Engineers Comments Regarding Surface Water Drainage

Application Reference:	AL/103/25/DOC	Reviewer Reference:	ADC/EXT4
Planning Officer:	Simon Davis	Date of Review:	13/01/2026
Site Name:	Land Adjacent to Woodgate Nurseries Lidsey Road Aldingbourne		
Application Description:	Approval of details reserved by condition imposed under AL/129/21/OUT in relation to conditions 16-Surface Water Drainage Scheme, 17-discharge flows to watercourses and 18-maintenance and management of surface water drainage.		
Assessment Number:	2 of 2

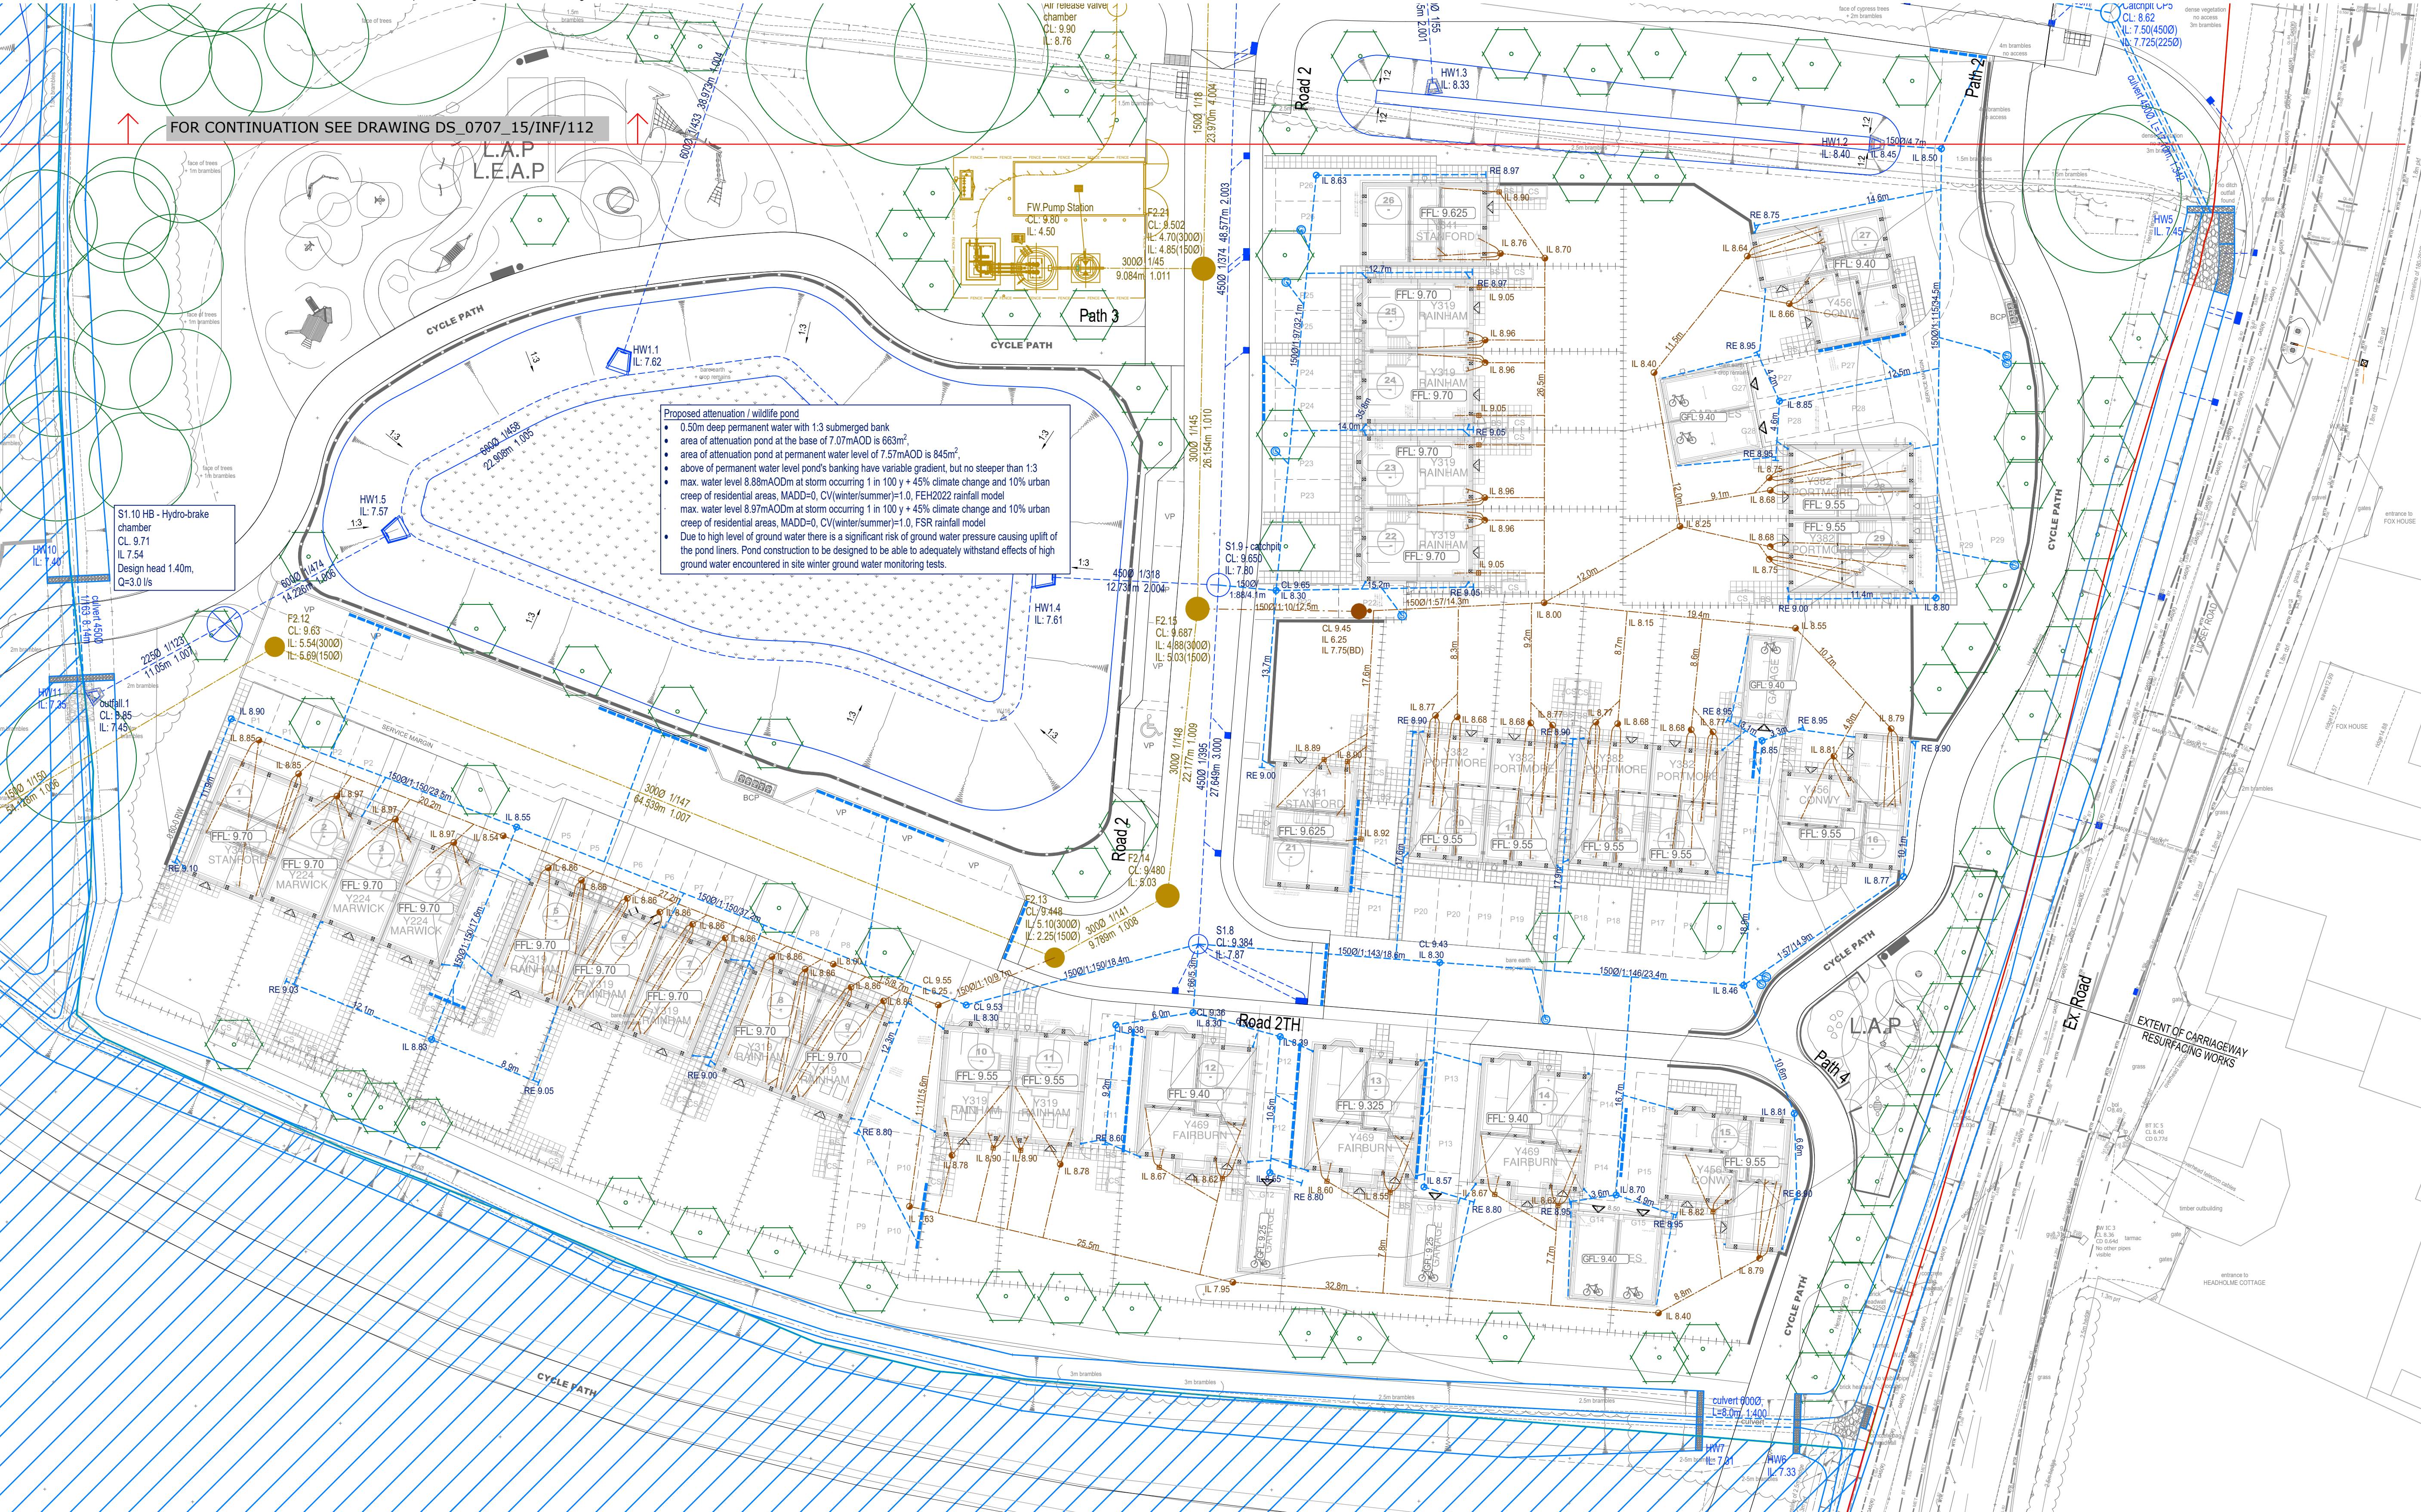
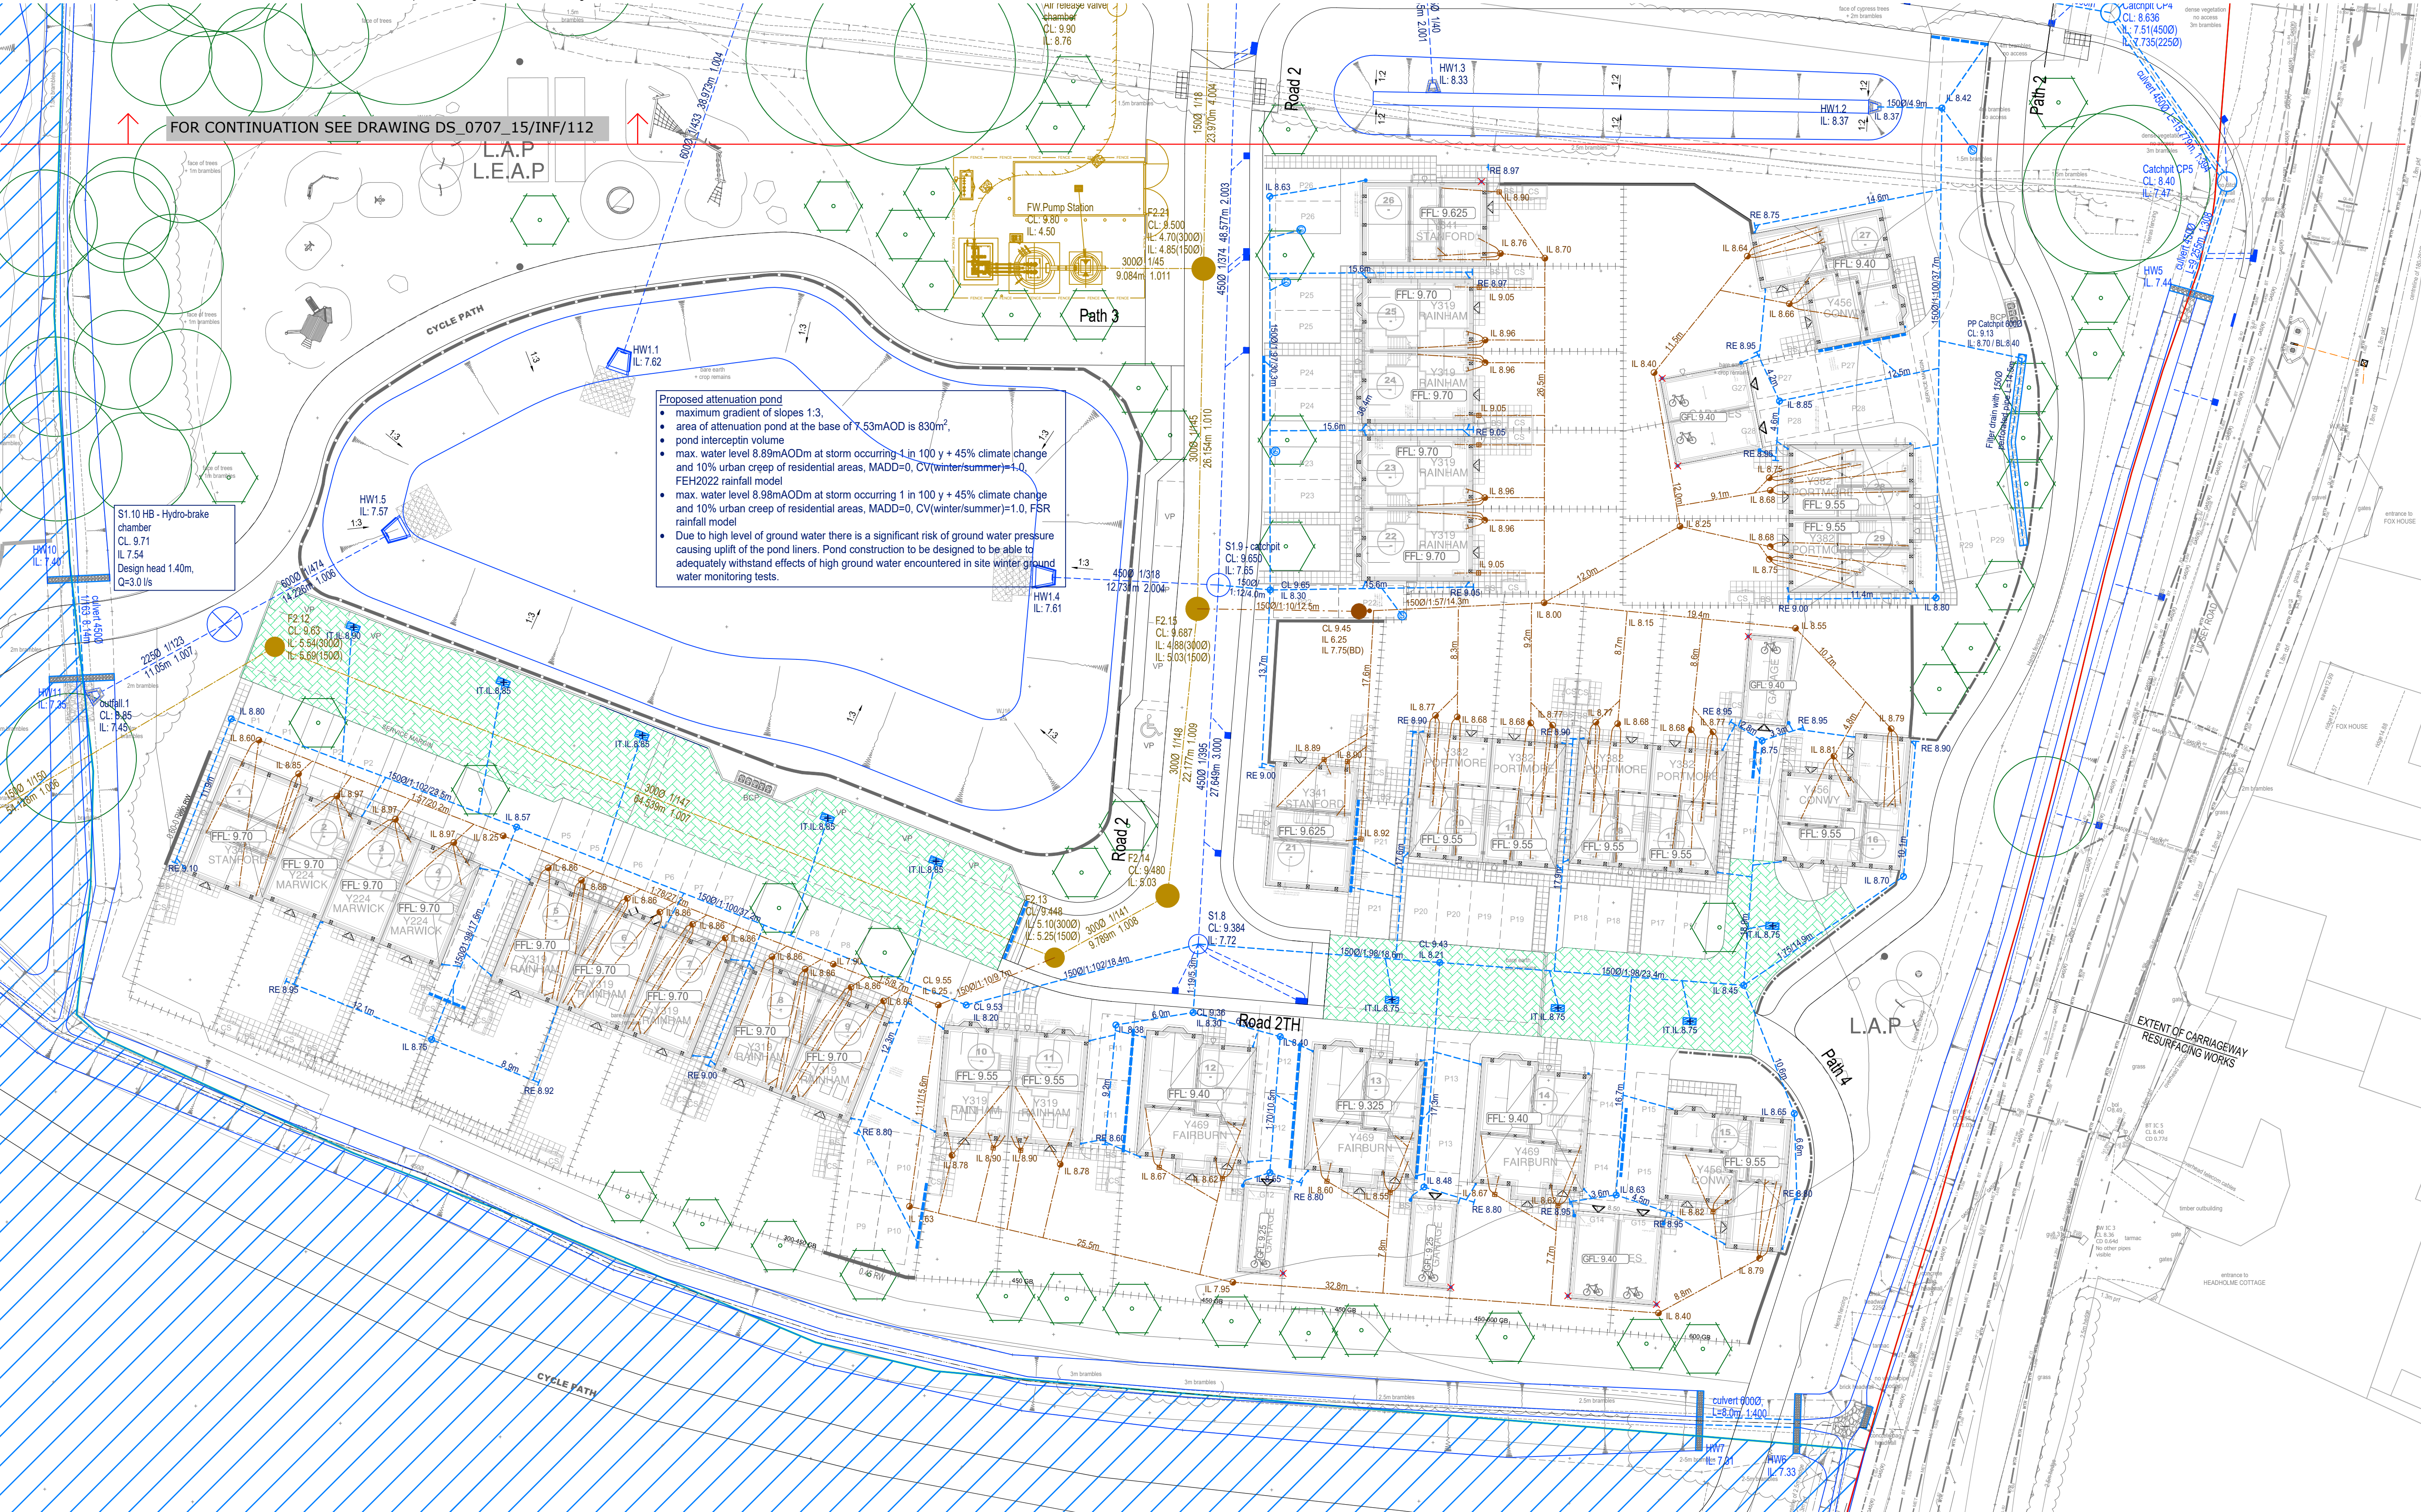
7	Please provide proposed landscaping and planting plants which clearly indicate the extent of the proposed root zones to ensure there is no conflict with the proposed drainage Designer Response 21/10/2025 Please find enclosed proposed landscaping layout GLS_020_170_P1_1300 Landscape General Arrangement	There appears to be clashes with proposed tree planting and SuDS basin and ditch easements. This needs to be reviewed and trees removed from easement, or clarification on maintenance operations in relation to these areas to confirm proposed tree locations will not impede future operations	Landscaping designs amended and there are no longer any clashes with proposed tree planting and SuDS basin and ditch easements. Amended landscaping plans included with resubmission.	Noted item closed	
8	Please review extents of drainage runs and clashes with proposed tree planting. There are multiple instances where drainage runs are shown to clash with new trees for eg.. outside plot 22, plot 18, plot 16,50,52,53,55, 56, 85 etc... Designer Response 21/10/2025 Tree locations shown previously don't tie in with the latest landscaping layout. Please find enclosed drainage layout drawings: DS_0707_15/INF/111-113. Some clashes still occur, but there is ongoing coordination between landscape	Updated information is required as part of the conditions. This information needs to be co-ordinated now	Landscaping plans have been amended and included with resubmission. There are longer any clashes between proposed landscaping and proposed drainage.	Noted item closed

10	Please provide a clear 3m maintenance easement around the basin and swales, as well as a clear 3m easement to existing watercourses	The easements clash with trees but concerning also appear clash with proposed buildings, fence lines and screen walls. Please review	Landscaping Plan and site layout have been amended to ensure there are no clashes with the 3m maintenance easement around the	Noted item closed
